RE: Cherry Creek Crossing Lot 111 Grading and Erosion Control Plan, El Paso County, Colorado (Kiowa Project No. 14028)

**CDR-17-003 Cherry Creek Crossing Grading and Erosion Control Plan
Review 3**

OVERLOT GRADING & EROSION CONTROL PLAN

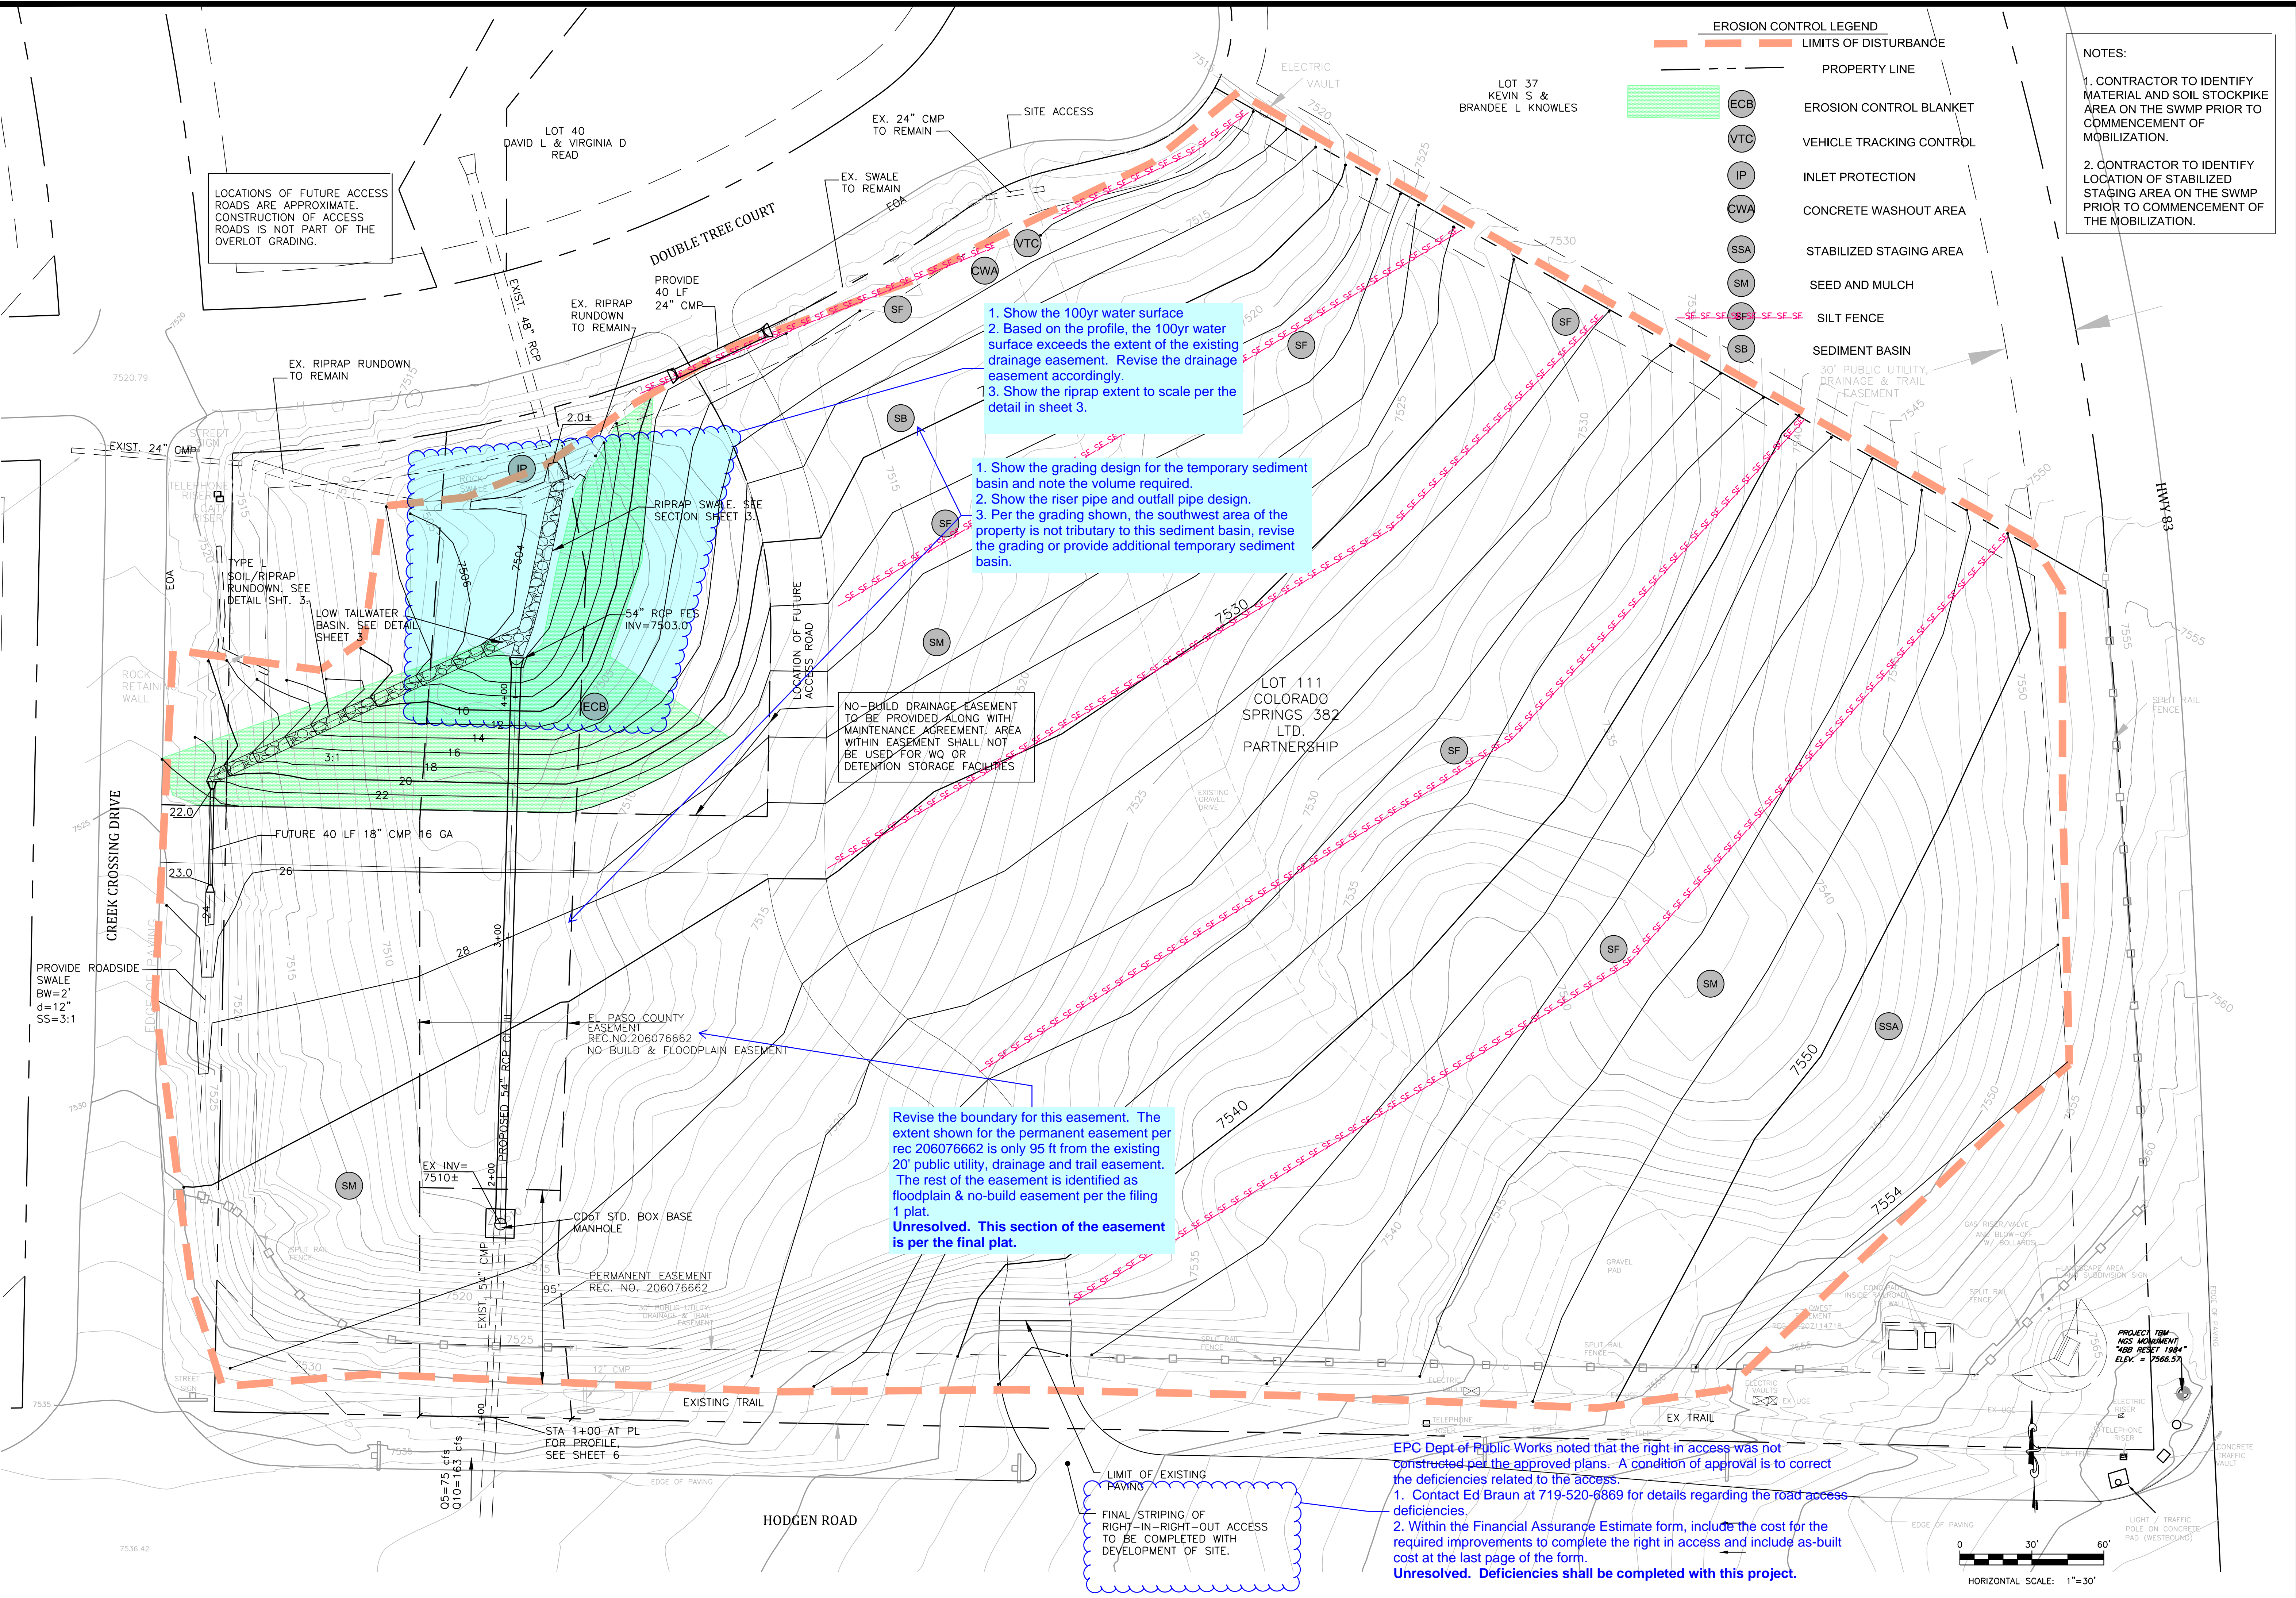
1. Reviewer requested that 100-year floodplain caused by the backwater from the 48-inch under Double Tree Court be added to the plans and provided a comment that it appeared that the floodplain would extend outside the easement to be provided. Floodplain has been added to the drawing. The floodplain encroaches slightly into the Double Tree Court right-of-way, otherwise it is contained within the drainage easement as proposed.
2. Regarding the comment related to the right-in-right out on Hodgen Road, it is Kiowa's understanding that the access in its current configuration has been accepted by the County and at this time no further work needs to be done.

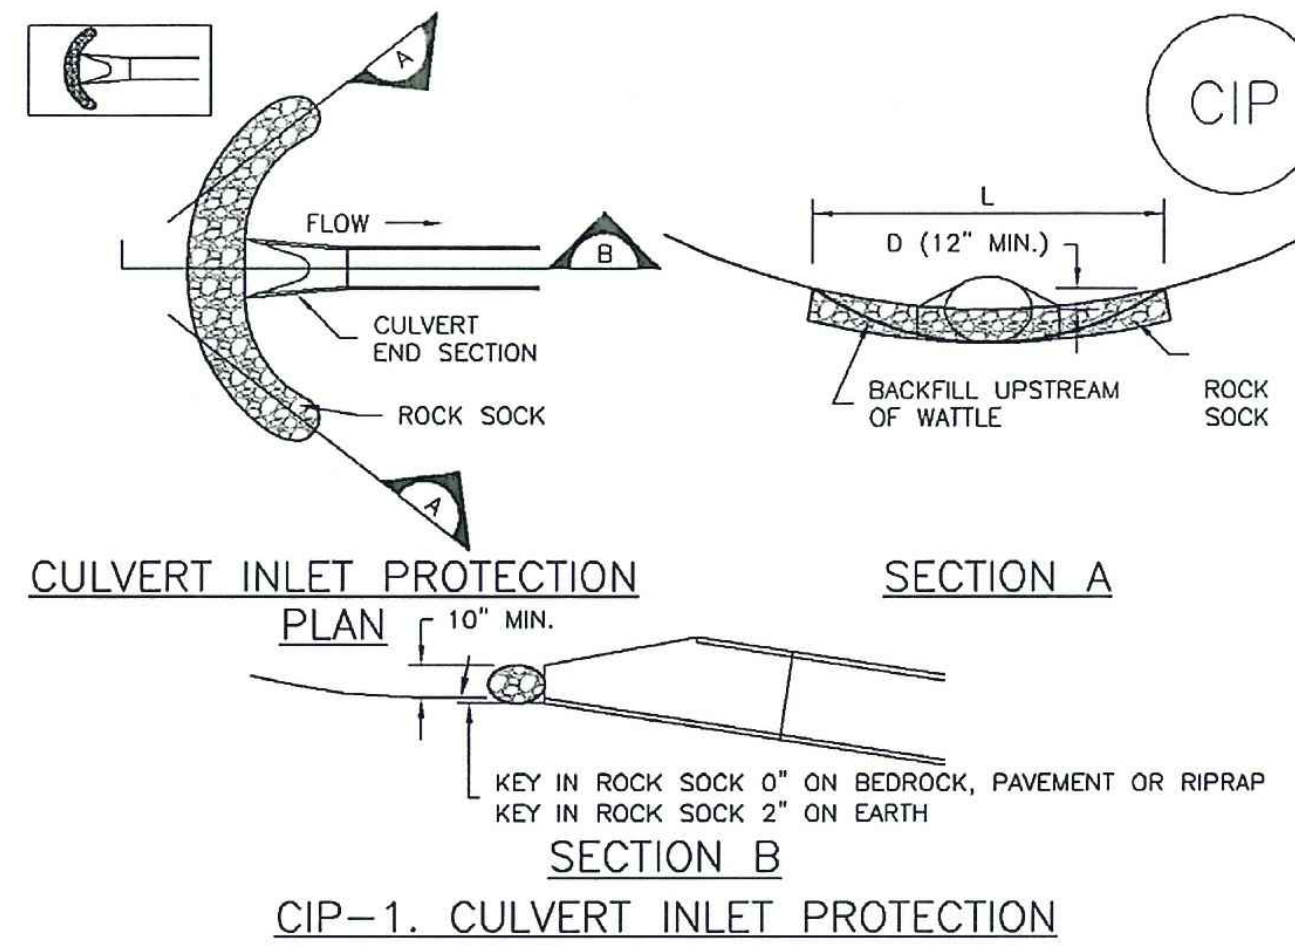
Sheet 4: Standard notes have been revised per the comment. Geotechnical evaluation has been referenced and included within the resubmittal.

HEADWALL LAYOUT STA. 4+10  
1"=2'

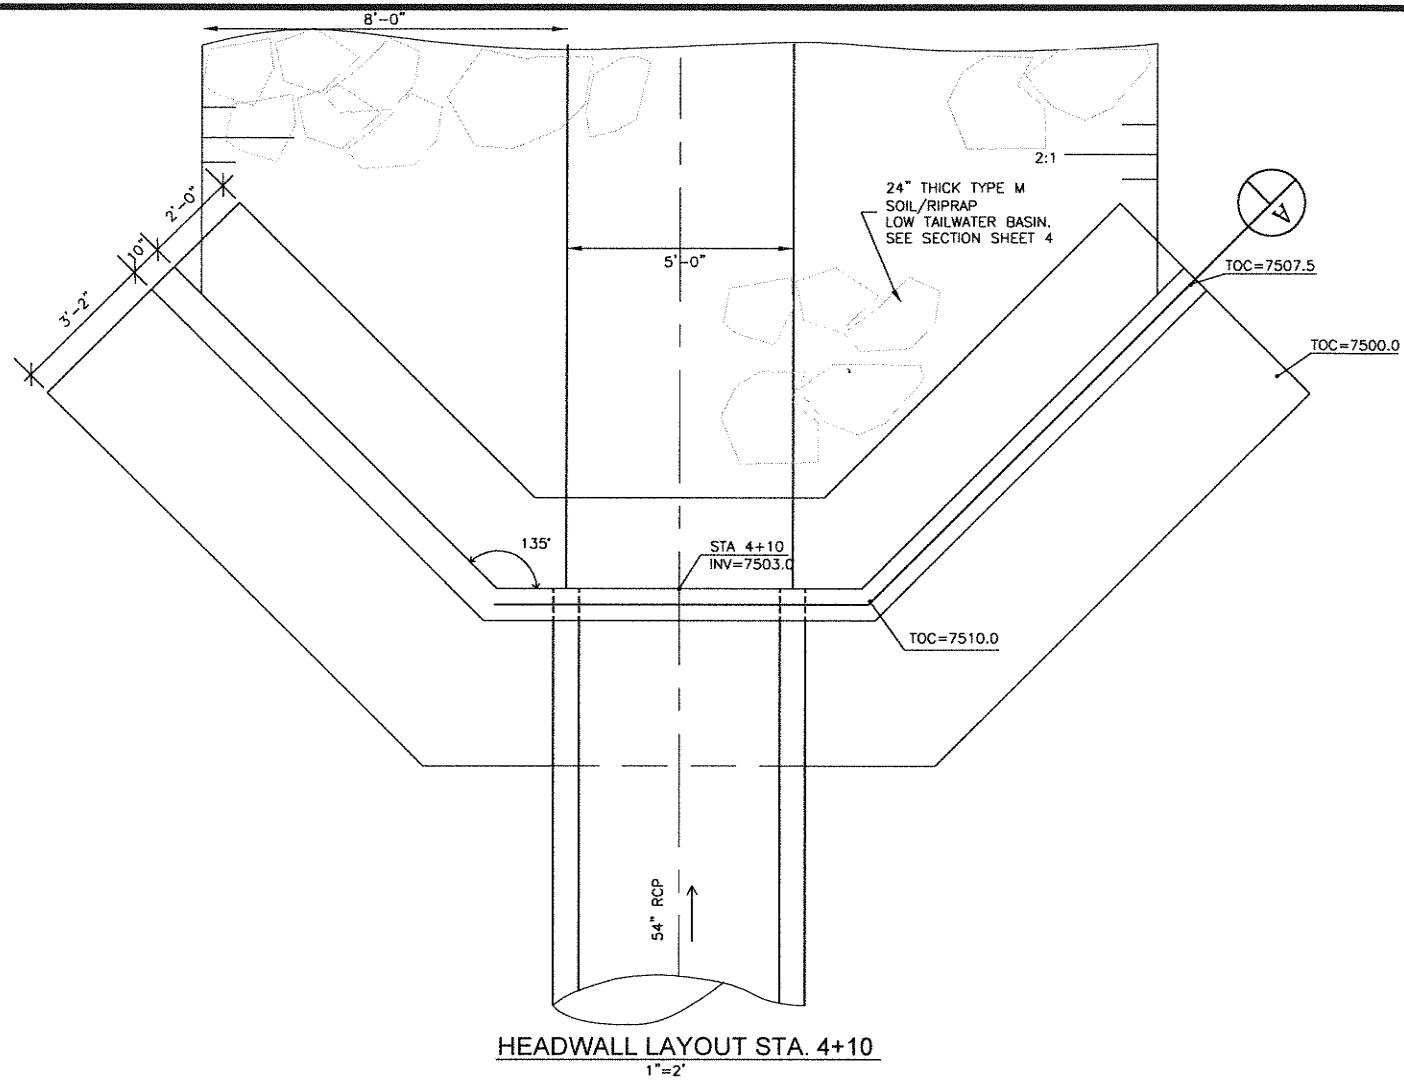
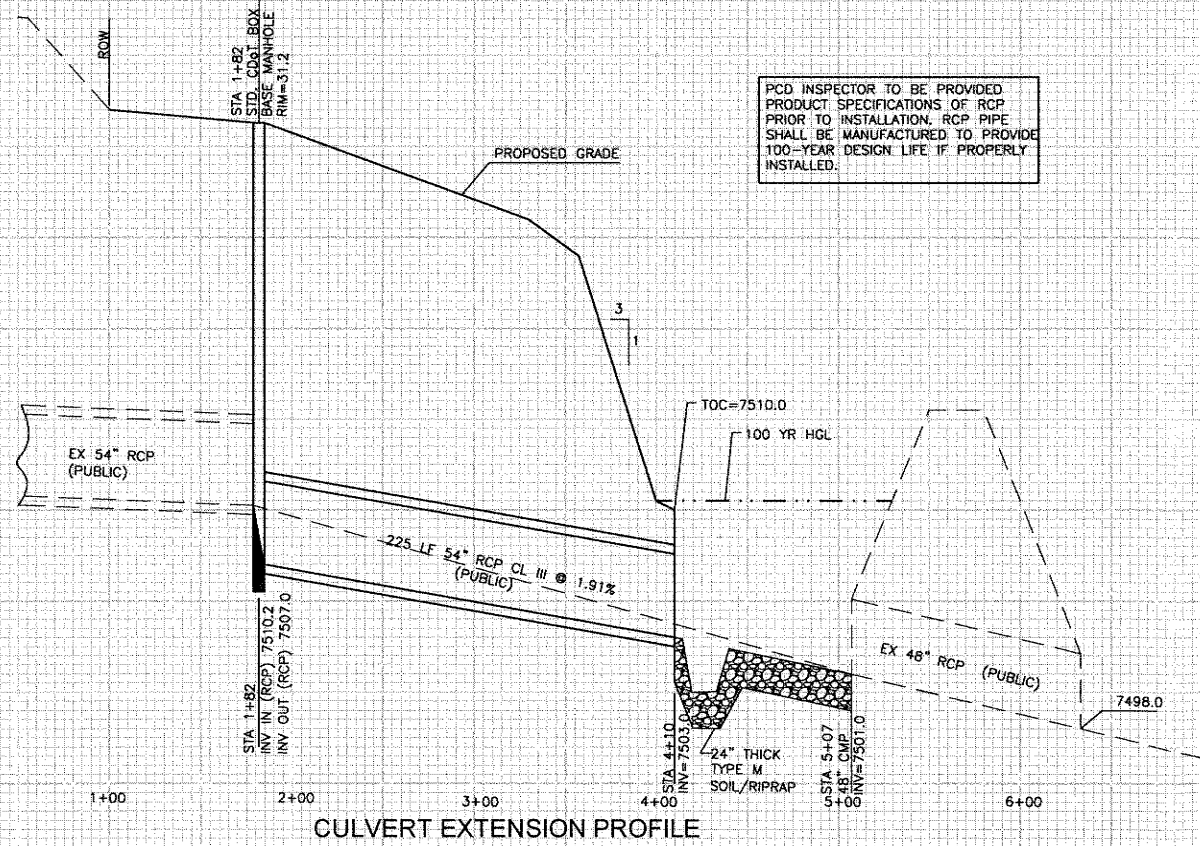
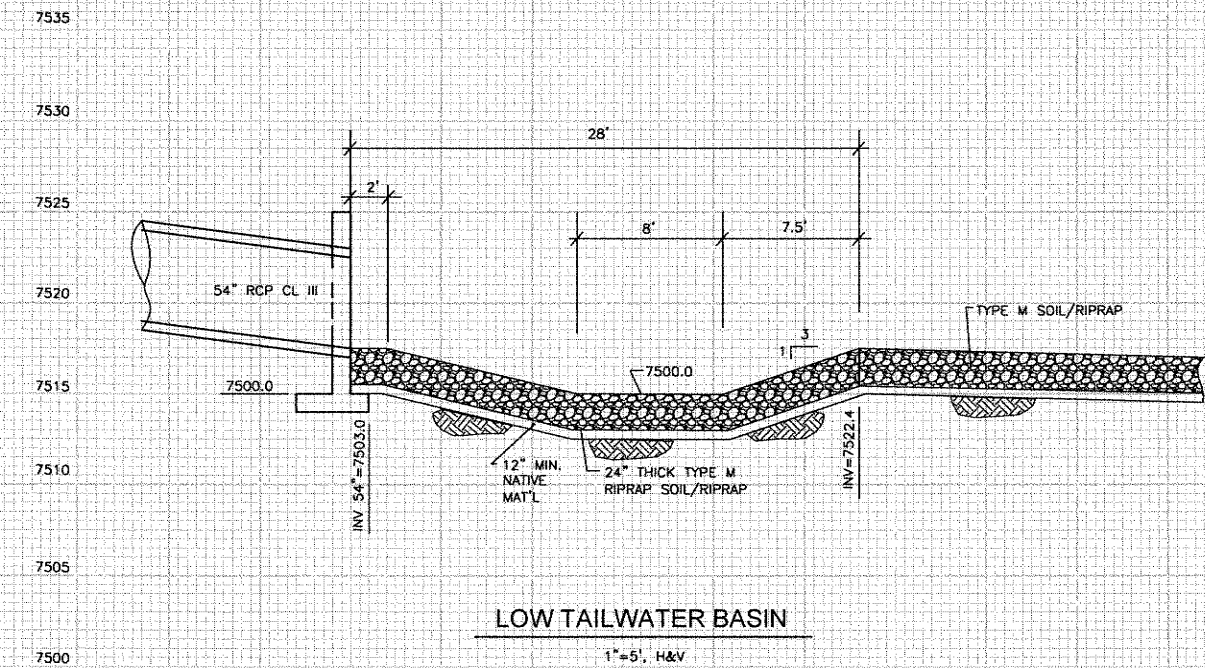
Sheet 3: All comments on this sheet have been addressed. Low tailwater basin with plunge pool per UDFCD criteria and CDoT standard headwall and wingwalls have been added to the design.
